## DESIGN JUSTIFICATION STATEMENT

Erection of two storey side extension to west elevation, including single storey rear extension, two storey side extension to the east to replace existing single storey garage and associated alterations

5 Dearnfield  
Upper Cumberworth  
Huddersfield  
West Yorkshire  
HD8 8NX

25073

title General arrangement as proposed
number 25073D-03-P02
scale 1:50, 1:100, 1:200
size A1

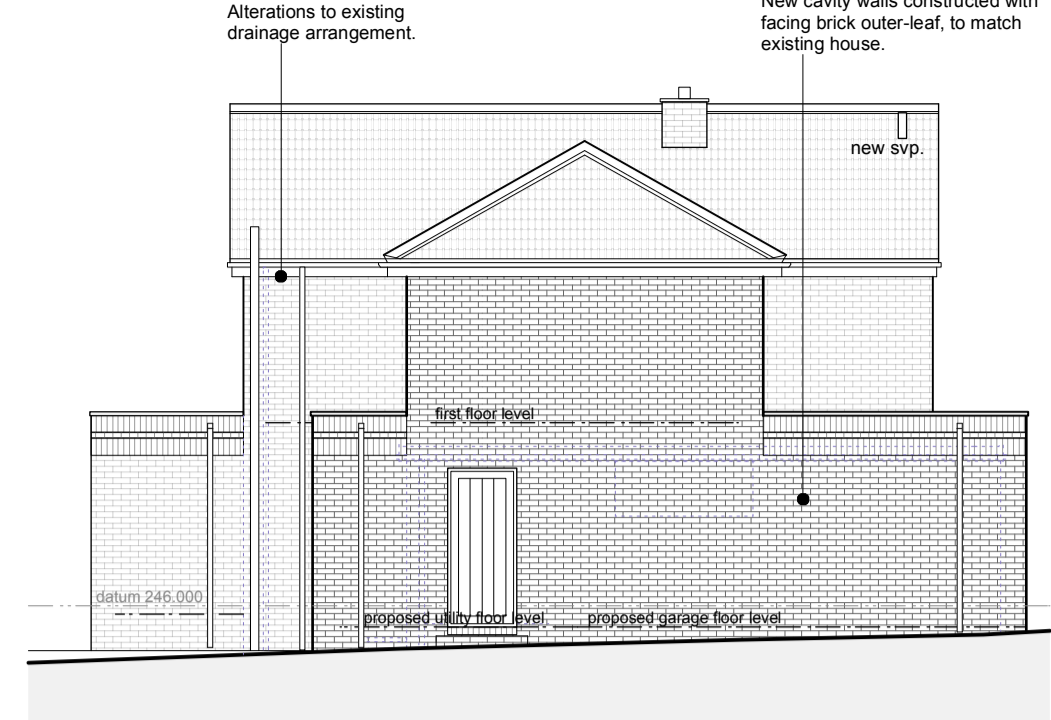
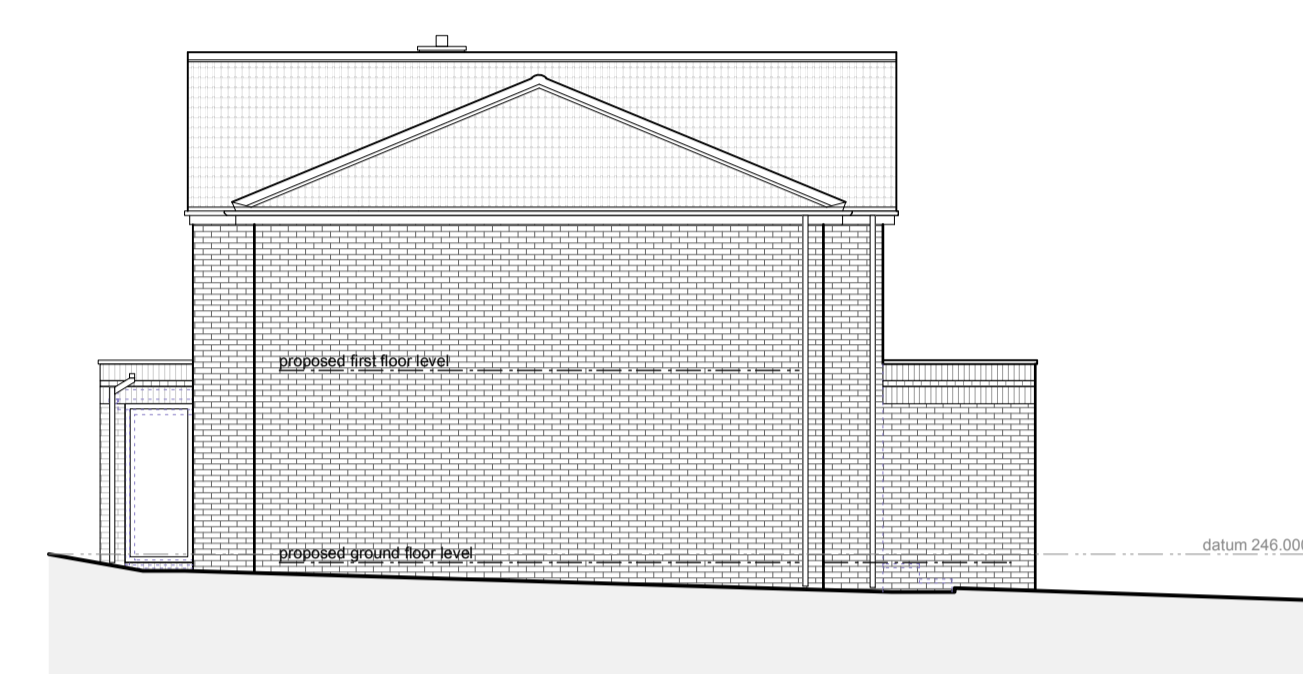
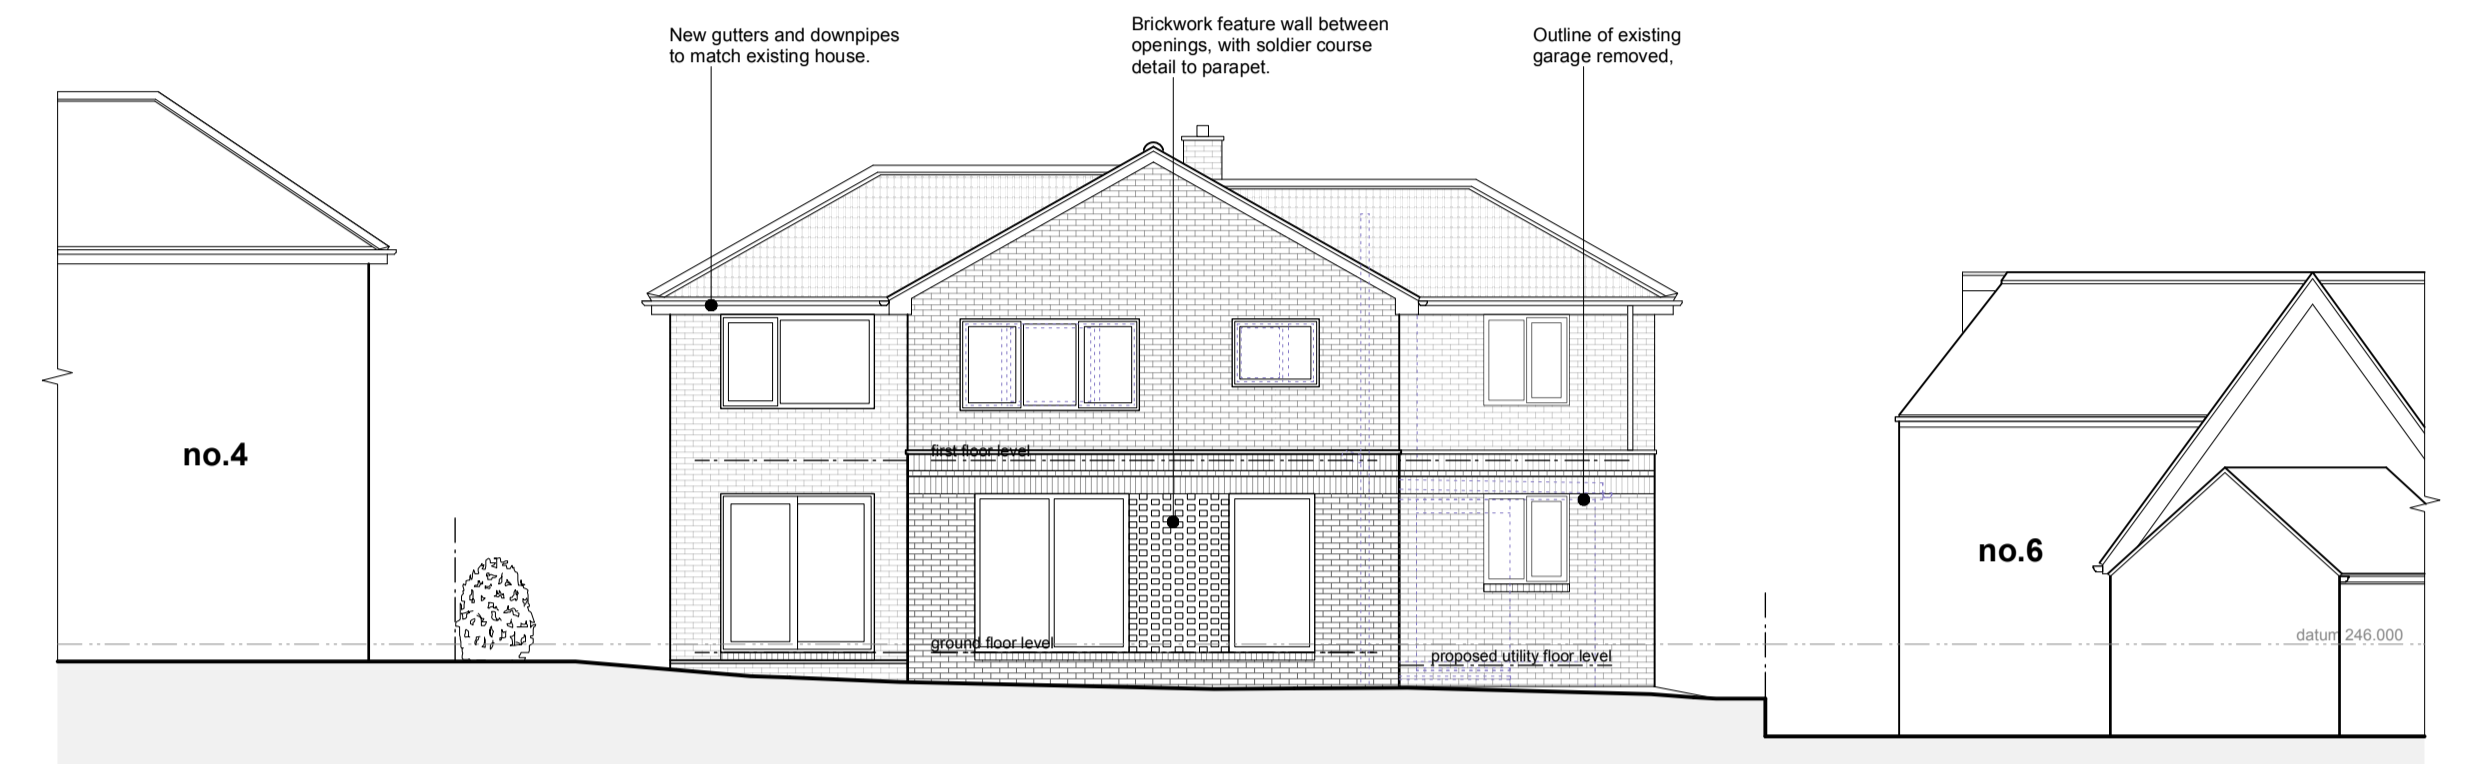
The officer comments relate primarily to the first-floor element of the proposed extension to the east elevation, raising concerns as follows:

- Proposals do not overcome the earlier reasons for refusal.
- Development does not read as a subordinate addition.
- Concerns regarding scale, massing and dominance.

- *Development does not present a fully subordinate appearance, extensions to both sides flush with the front elevation, resulting in a continuous and bulky massing. Extensions would therefore appear dominating and disproportionate additions.*

- Combination of **catslide roof to one side and pitched roof to the other**, result in an unbalanced and incongruous composition.

The current proposals have been specifically designed to ensure clear subservience in accordance with the Kirklees SPD.

Extension	Front Setback	Rear Setback	Ridge Height Difference
West	810 mm	785 mm	300 mm below host
East (first floor)	2250 mm	2160 mm	485 mm below host

These setbacks exceed the SPD minimum of 500mm by a significant margin. The ridge heights are also clearly subordinate. Therefore, overcoming the above reason for refusals.

The previous concern about mismatched roof forms is no longer relevant. The current proposal uses matching, sympathetic roof forms aligned with the architectural character of the host dwelling and the surrounding area, creating a balanced and well-integrated composition.

The proposed first-floor extension is set back to the same extent as that in the appeal application proposal, with the ground floor element being further set back than in the appeal application. The roof height is lower than the host dwelling and the massing remains recessed and non-oppressive. The appeal found no harm regarding light or outlook, and the revised scheme maintains these mitigating features.
